Our Ref: FP/268/17/PL
Your Ref:

Town & Country Planning Act 1990 (as amended)
Town and Country Planning (Development Management Procedure) (England) Order 2015
Application for Planning Permission

Development Detached 9No. bedroom annexe for Beachcroft Hotel with 9No. car parking spaces.
Location Beachcroft Hotel Clyde Road Felpham

PROJECT	Gull Point Suites - On the Beach	DATE	20/09/17
TITLE	Second Floor Plan	DRG NO	IBA/480/05
SCALE	1 : 50	REVISIONS

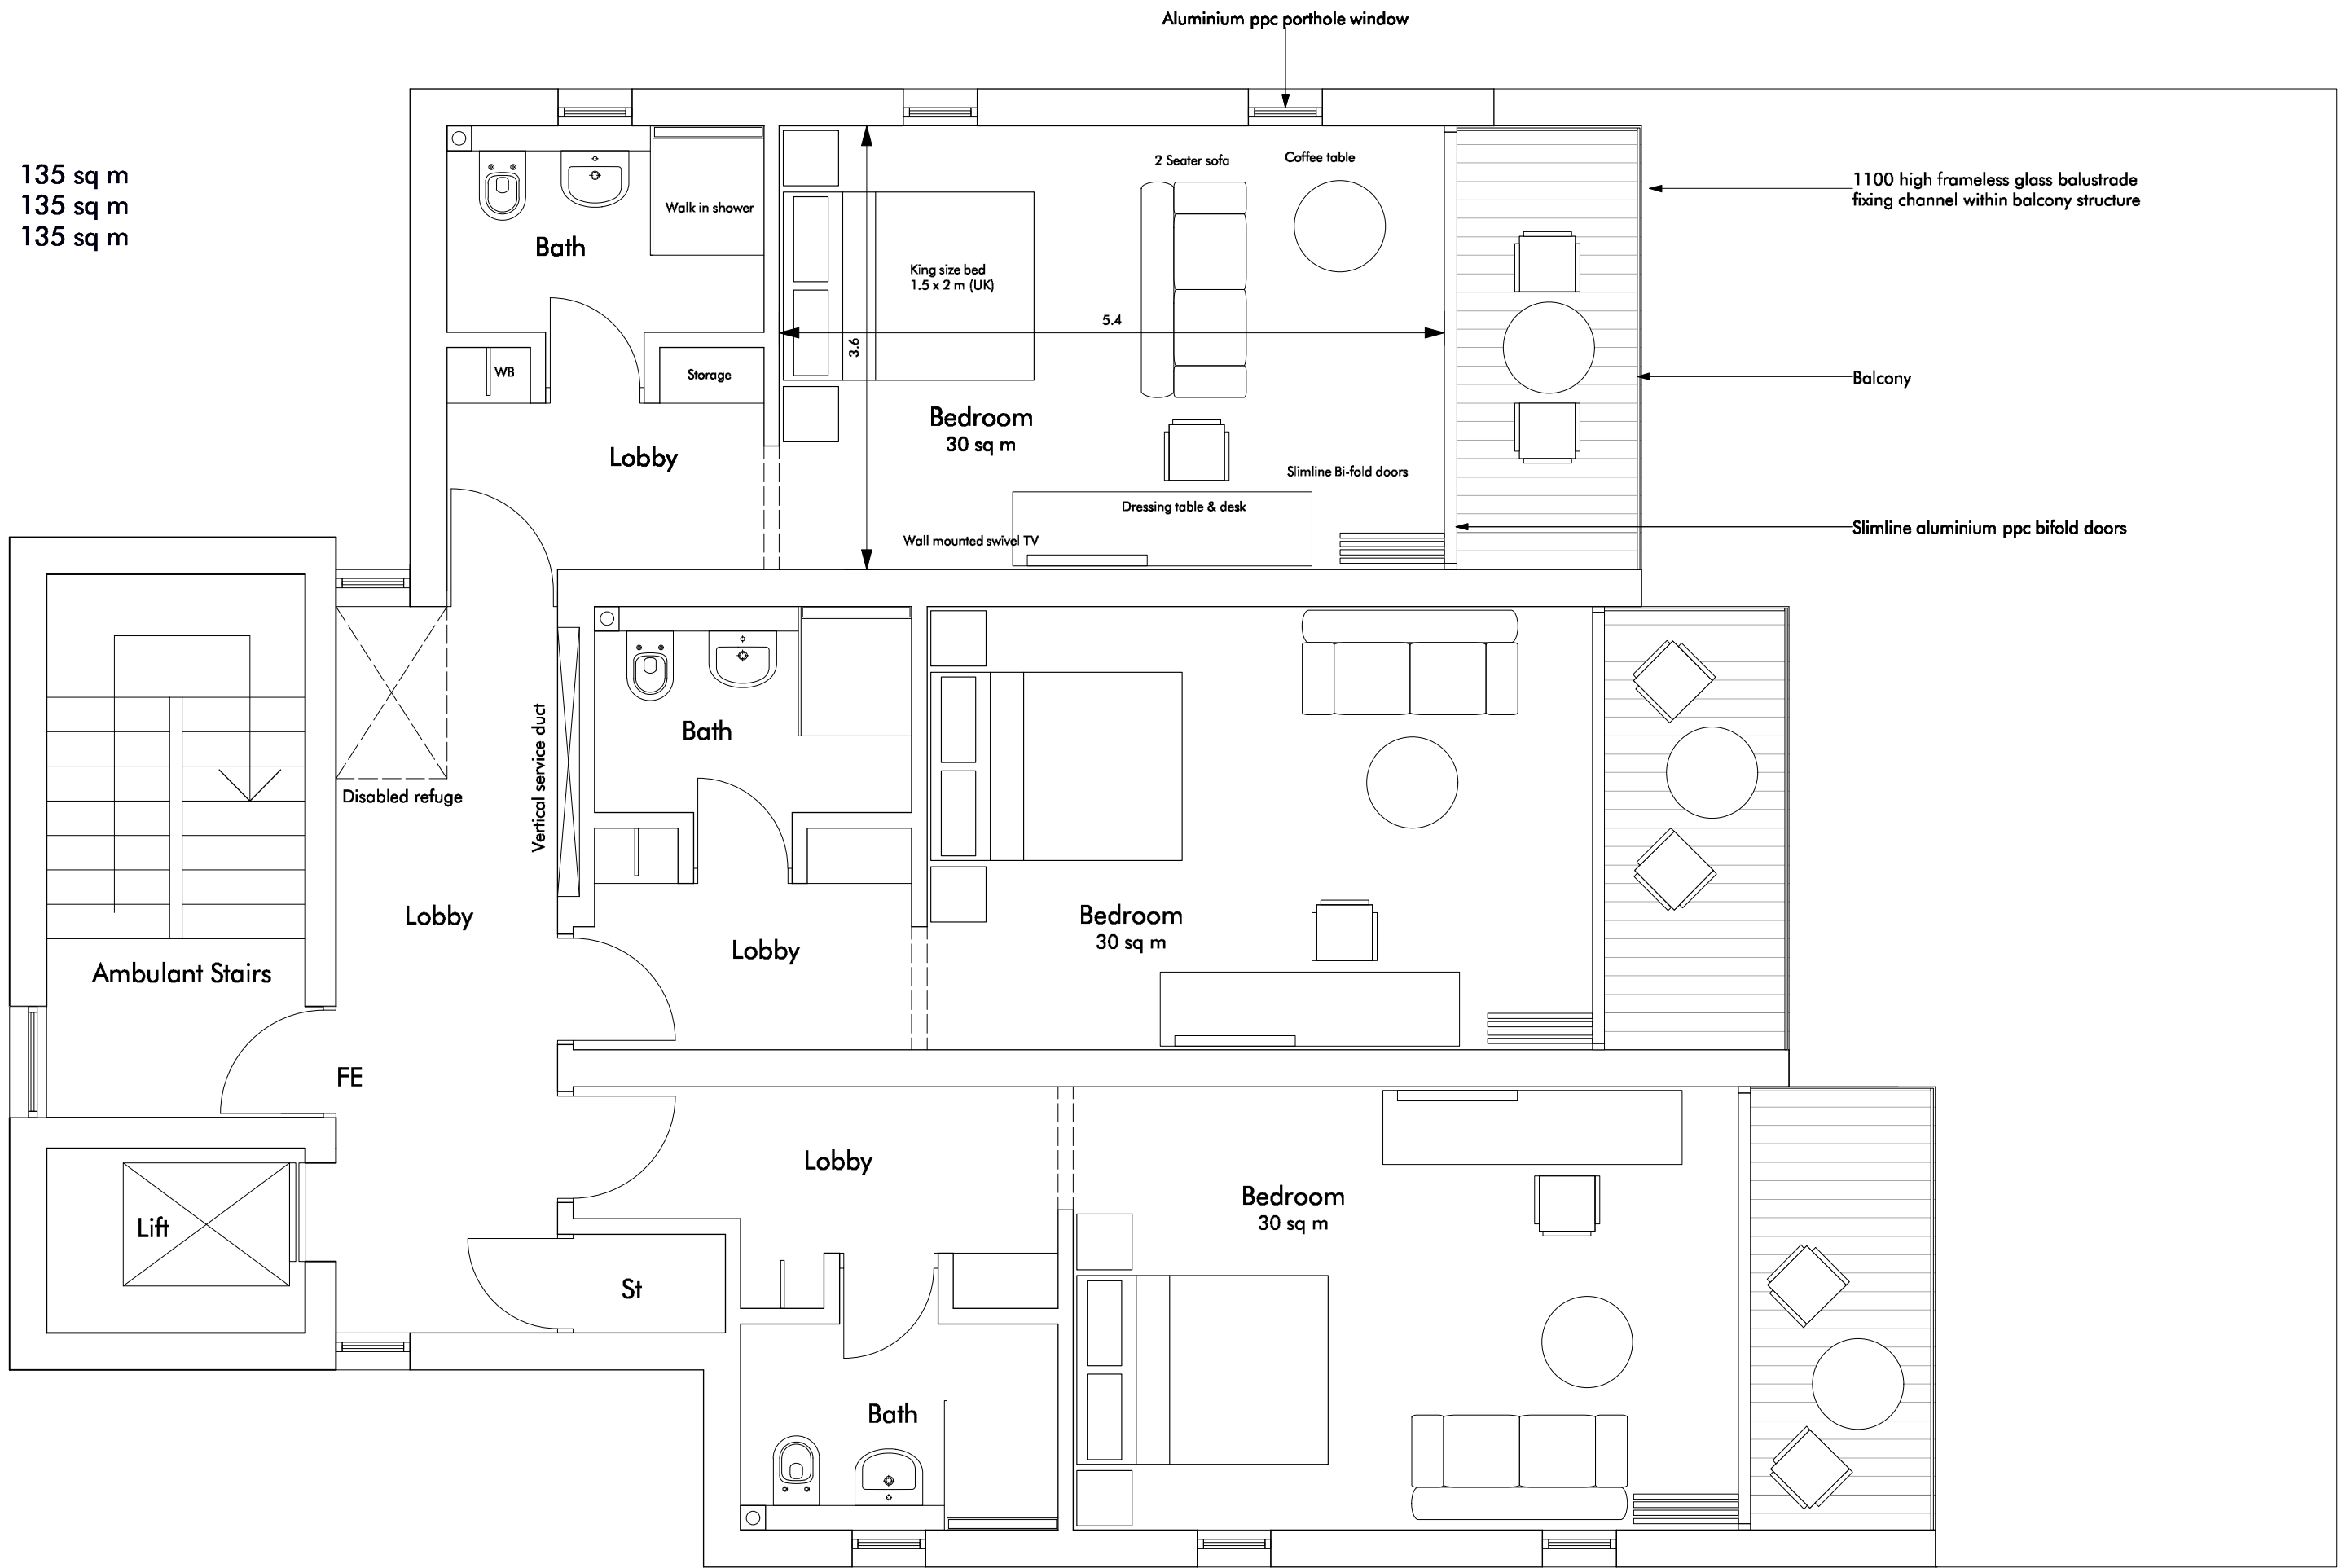
There appears to be a small window not indicated on the North elevation however, has been clearly shown on the 1st, 2nd and 3rd floor plan.
